Addendum No. 2

RE: Contract ID C203027

Cleveland County (R-2707AB) (Proposal No. 1)

US-74 (Shelby Bypass) From East of SR-1161 (Pleasant Ridge Road) To
West of SR-1314 (Hoyle Road)

UTILITY CONSTRUCTION PLANS CLEVELAND COUNTY

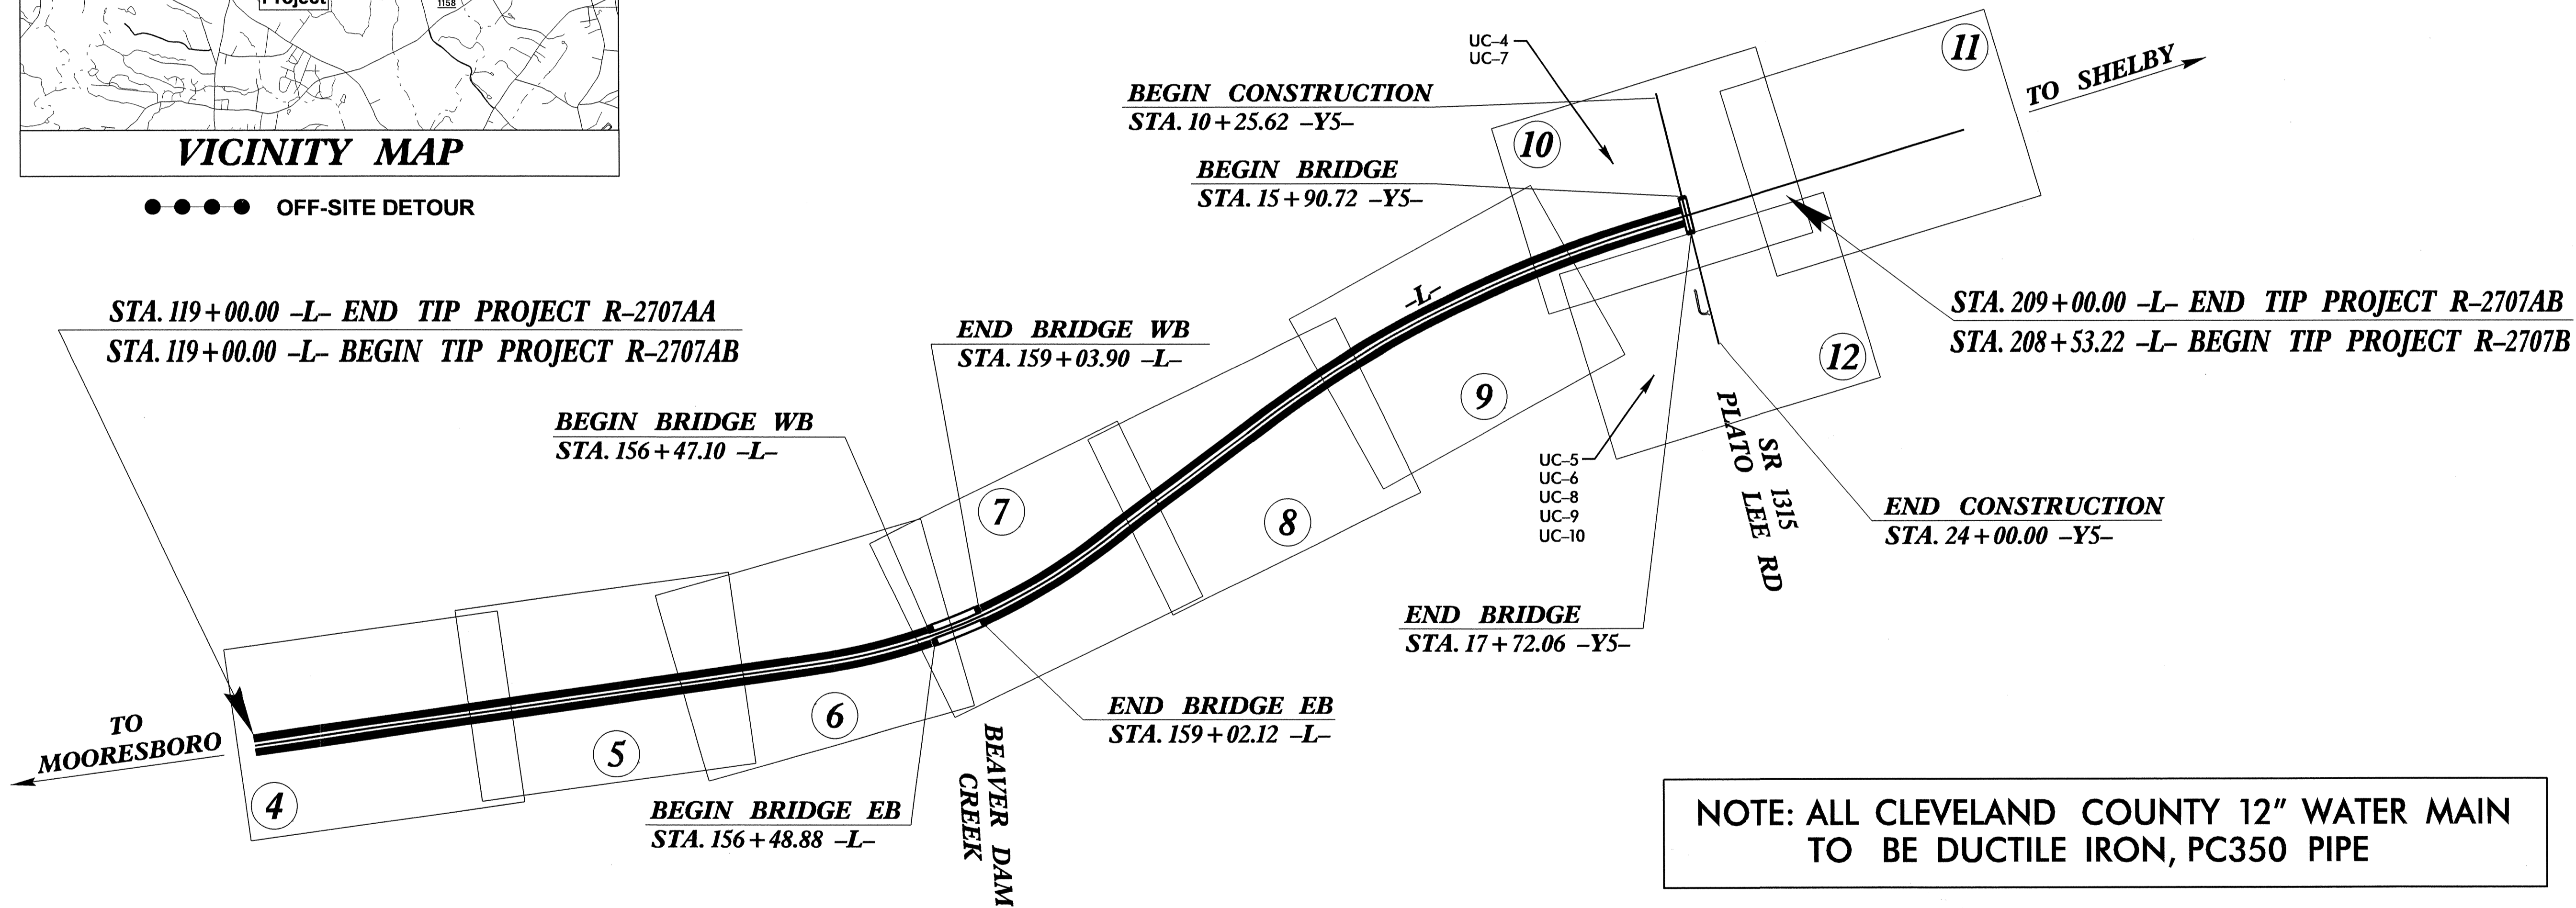
On Sheet No. UC-1 a note has been added concerning the 12" Water Main. Please void Sheet No. UC-1 in your plans and staple the revised Sheet No. UC-1 thereto.
